Reference No:	<b>2025/62/93129/W</b>
Site Address:	395, Manchester Road, Marsden, Huddersfield, HD7 6DP
Description:	Raising of roof height, demolition of existing rear lean-to extension and erection of two storey rear extension with associated alterations
Recommending Officer:	Joshua Merriman

**DECISION – Conditional Full Permission**

## **Officer Report – 2025/93129**

first floor plan

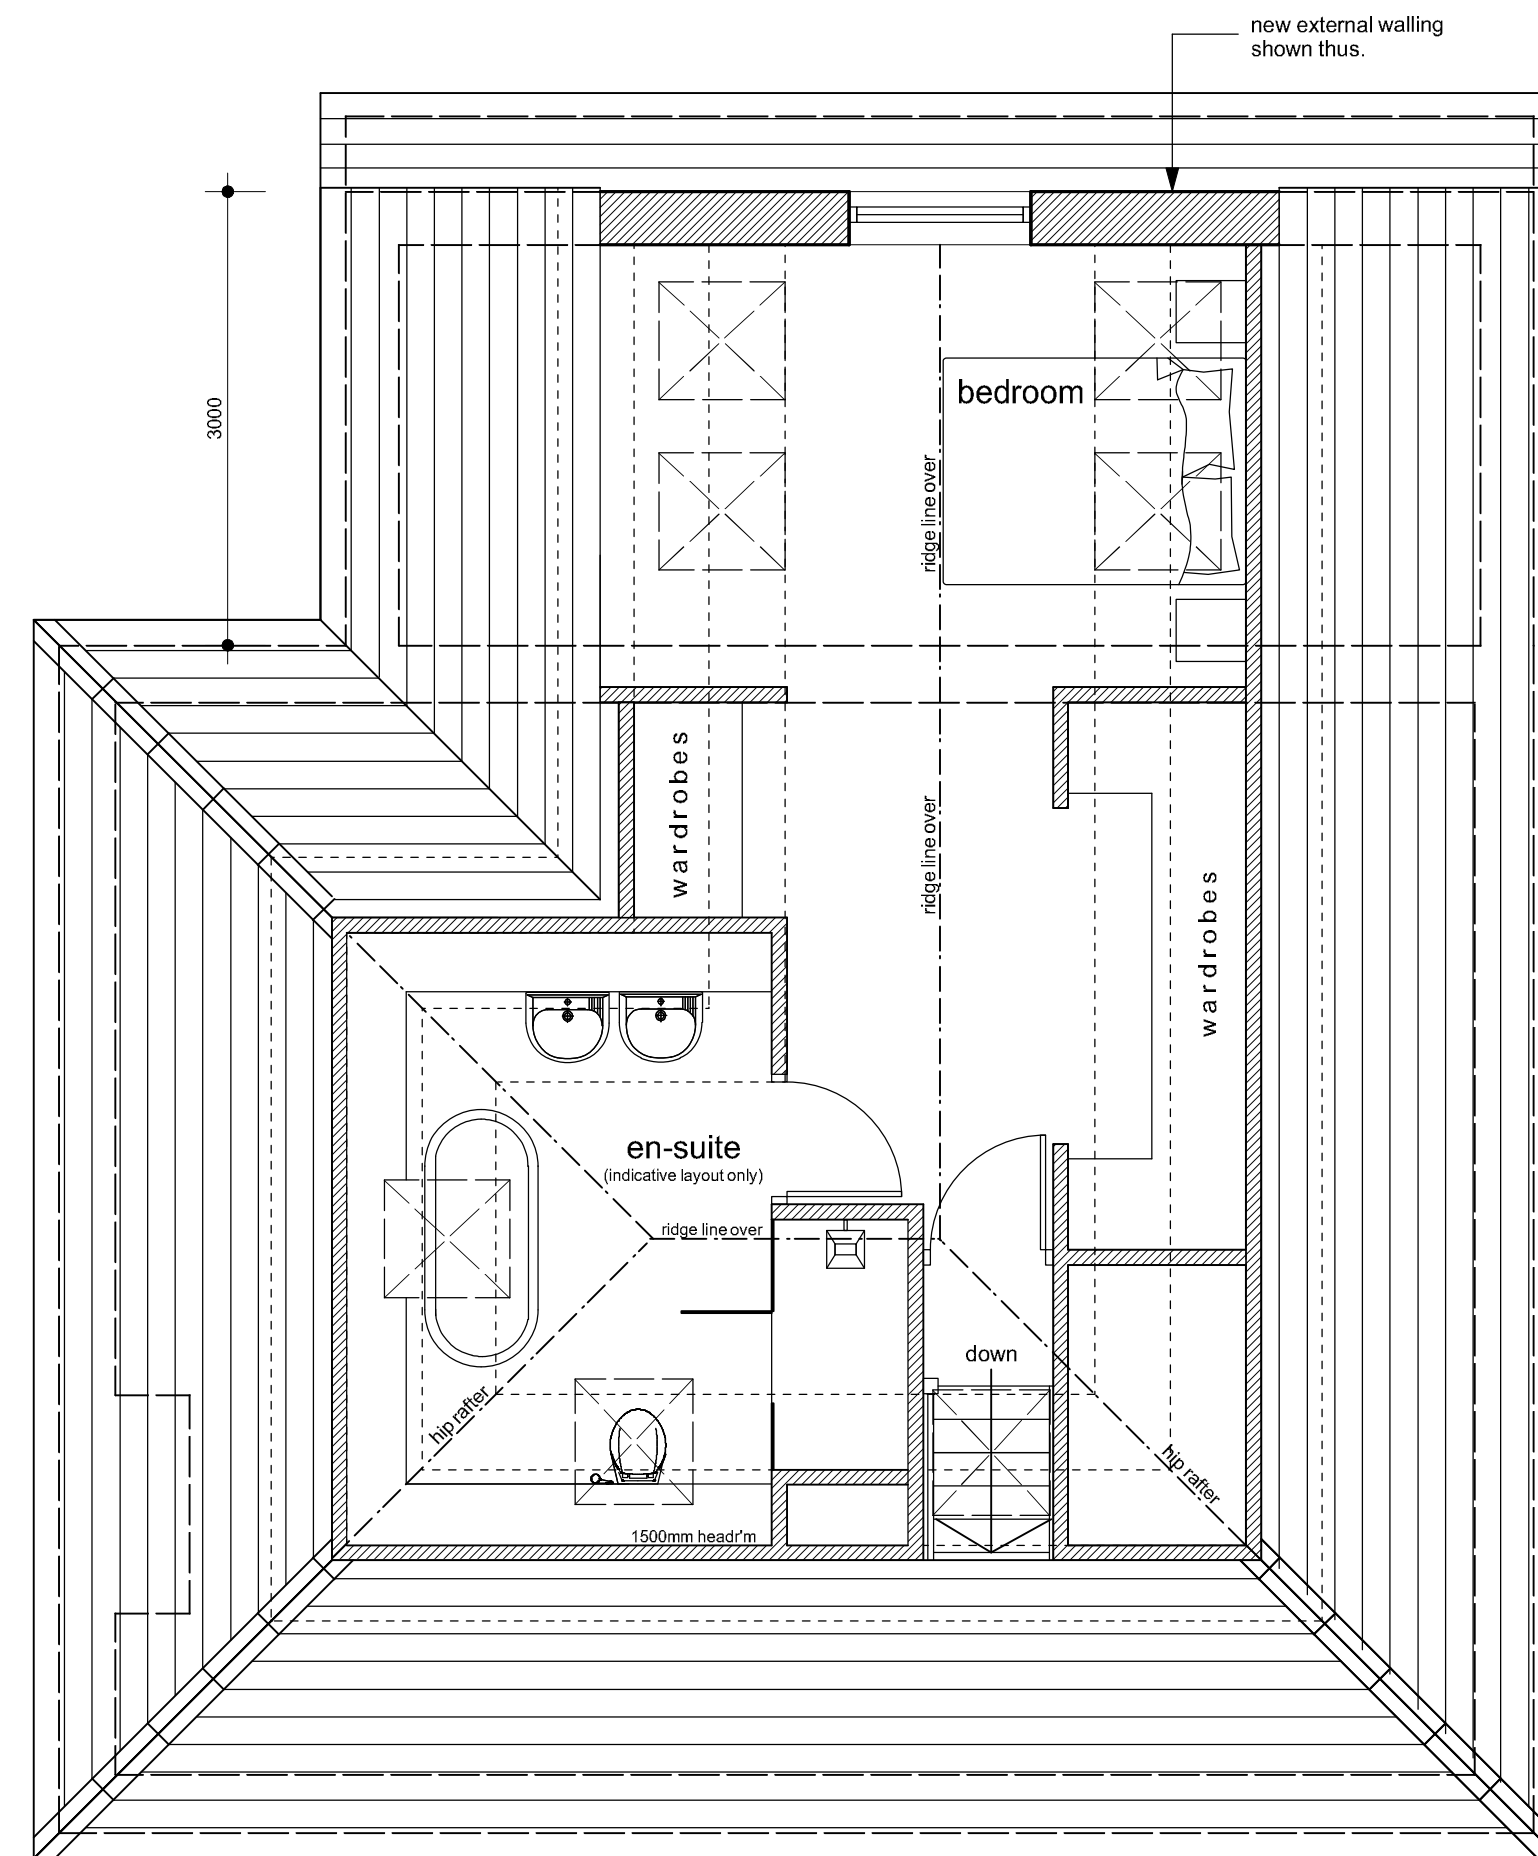
The case officer sought it necessary to reduce the overall scale of the development as the application site is located within the Green Belt. Upon communicating this to the agent, amended plans were submitted showing a reduction in the increase in eaves height and total height of the rear extension by 350mm, and a reduction in the projection of the rear extension from 3.5m to 3m.

The extension is set in approx. 3.5m from no. 393 and it meets the 45 degree code as shown on the submitted floor plan. Given the generous separation distance in place, the proposed rear extension is not considered to result in adverse overbearing or overshadowing impact that would warrant a refusal and is therefore acceptable.
